Project #: EART-05

Subject: Technical Review of Coal Ash Management in Environmental Impact Statement for Bayswater Power Station Upgrade SSD-9697--

Environmental Justice Australia and Earthjustice retained Burgess Environmental Ltd. (Burgess) to review and comment on the Project EIS, focusing on environmental issues associated with waste coal ash and salt management. The following documents were filed and available for this review (see References) as part of the EIS:

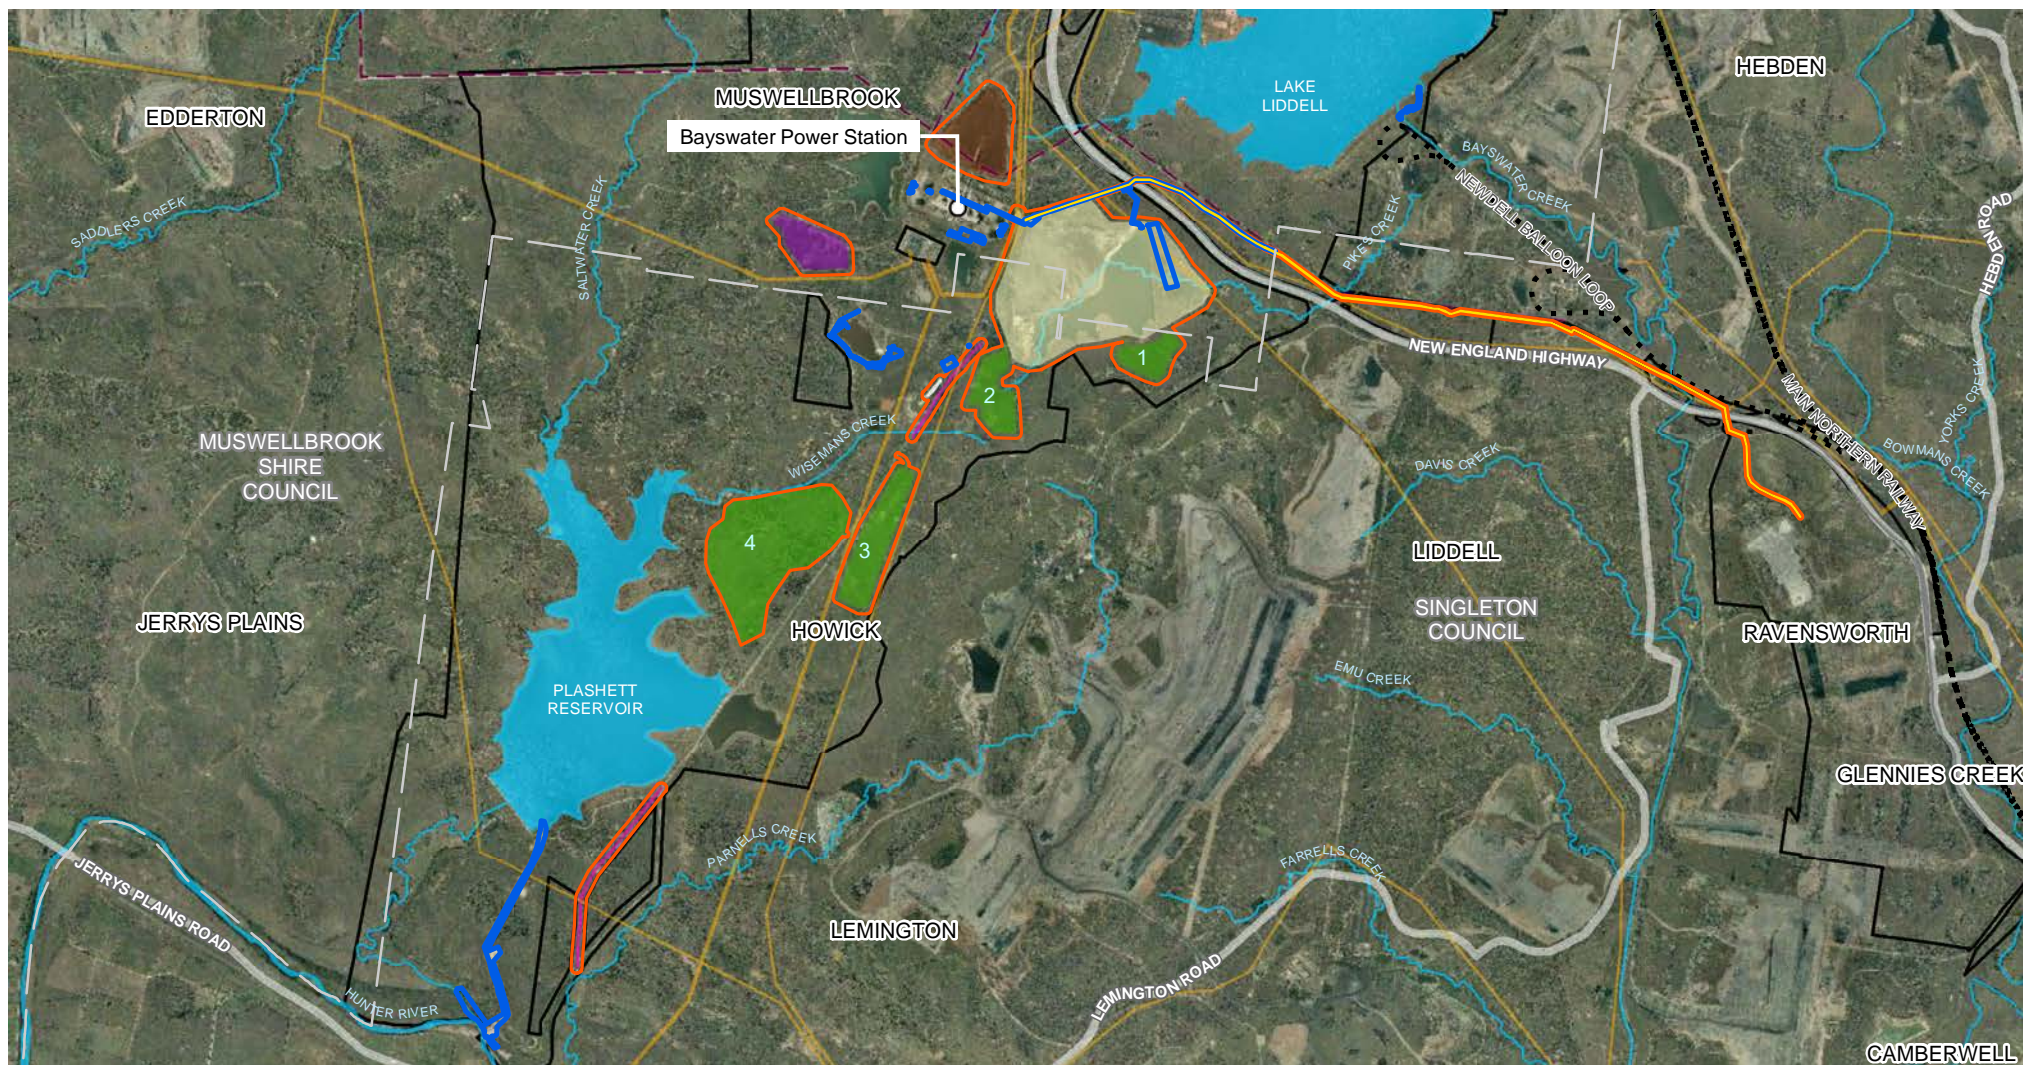
AGL plans to increase the available disposal capacity in the coal ash impoundment by 12.5 million m³ by increasing the area of coal ash disposal by approximately 17 hectares and the height of coal ash dam segments by varying amounts. These proposed modifications are not described in any technical detail. The nature of the existing dam construction is not described in the EIS and the Bayswater Ash Dam Augmentation Design Report completed by Aurecon (2019) was not included in the information package made available by AGL. Infrastructure upgrades include modifications to the coal ash slurry and water return systems.

It is important to note that the seepage flow rates bypassing the seepage collection systems are similar under existing and post-augmentation conditions. Accordingly, the proposal does not prevent or minimize the release of coal ash impacted water to the environment.
